ARUN DISTRICT COUNCIL			
No.	BN	27	09
Received

11th February 2010

Angel's Nursery, Barnham – BN/27/09

I write with reference to the above Planning Application. I am coming back to you on technical and principle matters following the submission and receipt of a number of consultation responses (which can be viewed on the Council's website). I have not yet received all the consultation responses but, as timescales are very tight in the absence of a Planning Performance Agreement (PPA), I thought I would come back to you at the earliest opportunity to allow you some time to address the issues.

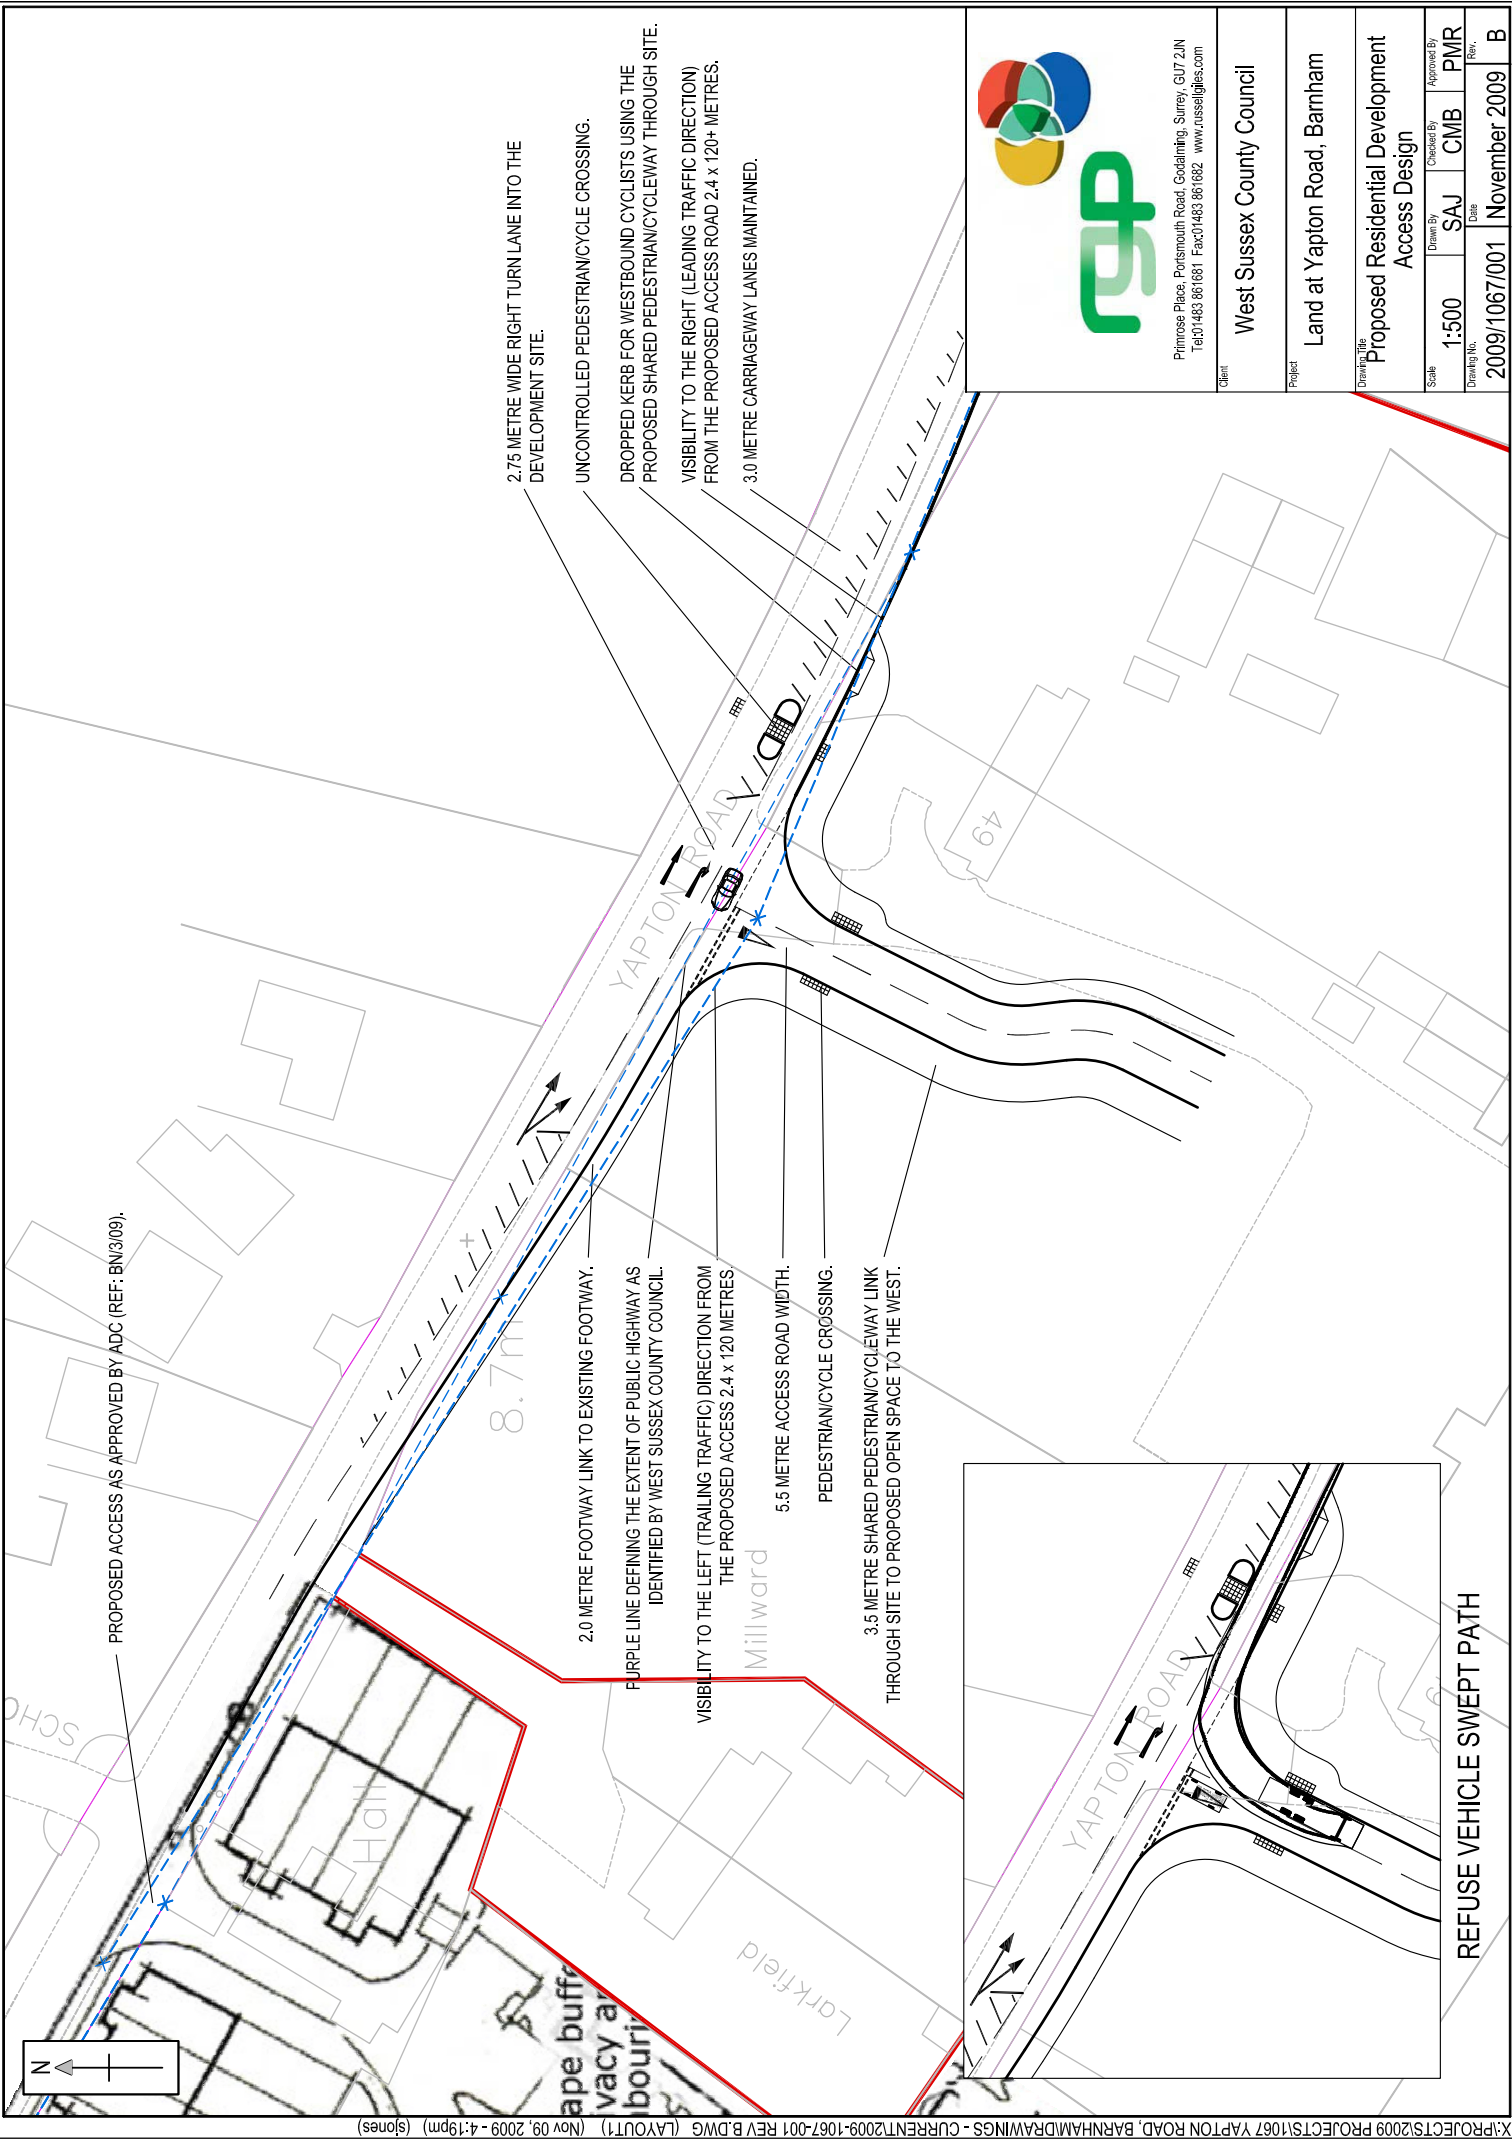
Can you confirm which trees are proposed to be retained in your indicative layouts you have submitted? All that is apparent from the indicative layouts is the existing boundary treatment on the south and east boundary and the two Oak trees within the proposed open space (T15 and T16). However, the absence of RPA does not allow the Council to confirm that the layouts ensure these remain. Any such vegetation to be retained must be suitably protected for the development work by appropriate fencing. This will need to be identified on a plan.

The western boundary landscaping appears differently on each of the three indicative layouts without annotation and no northern boundary landscaping is shown - this must be included. There is also no indication of any other trees or hedgerows within the site being retained. The Council consider that the Group T18-23 should be retained as part of any layout and acknowledge that this has a significant impact on potential layouts and developable areas. However, these are mature and highly prominent trees with no significant defects.

The Flood Risk Assessment (Section 7B) states that and any pond that may be required for additional storage could be the children's play area. Any pond/swale would need to be a stand alone feature and the children's play area should be useable even in wet conditions (with children's safety in mind as well). Again, these features need to be built into the indicative layout to consider the maximum housing numbers in the application.

With provision of LEAP's on the adjoining site, it is considered that the LAP should be more centrally located in the indicative layouts so that the use is principally from residents of the proposed scheme where every proposed dwelling has good access to it.
